Re: First New Mexico Bankshare Building

DRAINAGE REPORT AND DRAINAGE PLAN CHECKLIST

Ref: First New Mexico Bankshare Building
(J14-D27)

STORM INLET PLAN

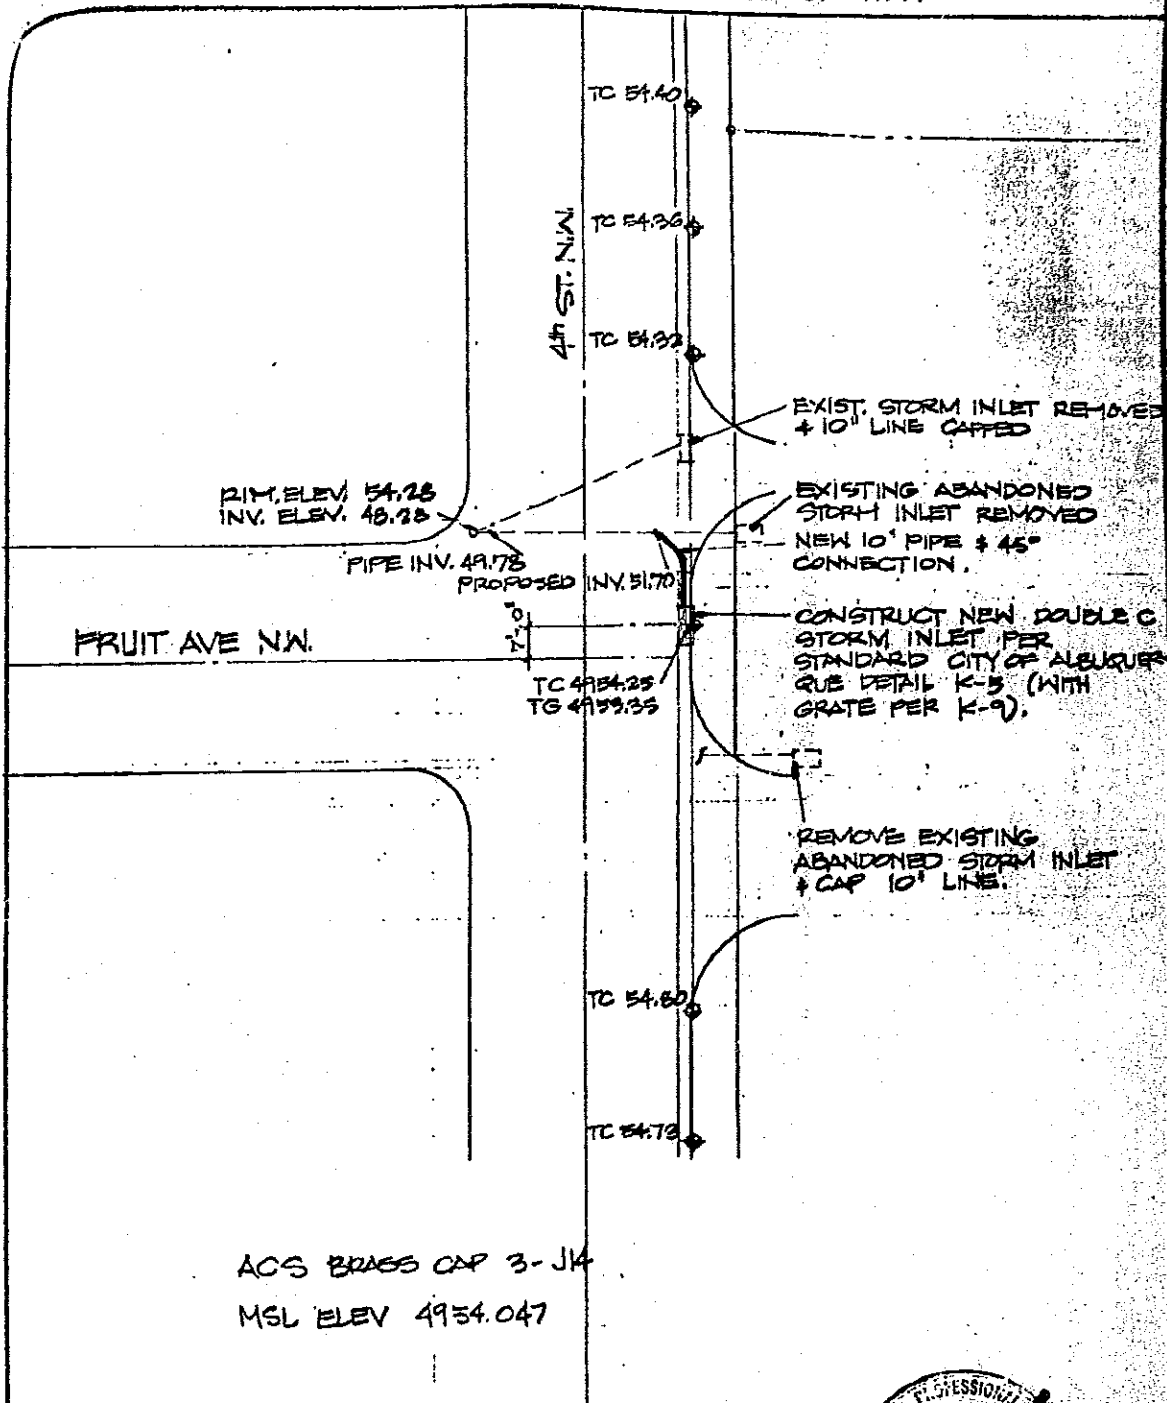
* (M) Provide complete cross-sections for the two proposed discharge systems
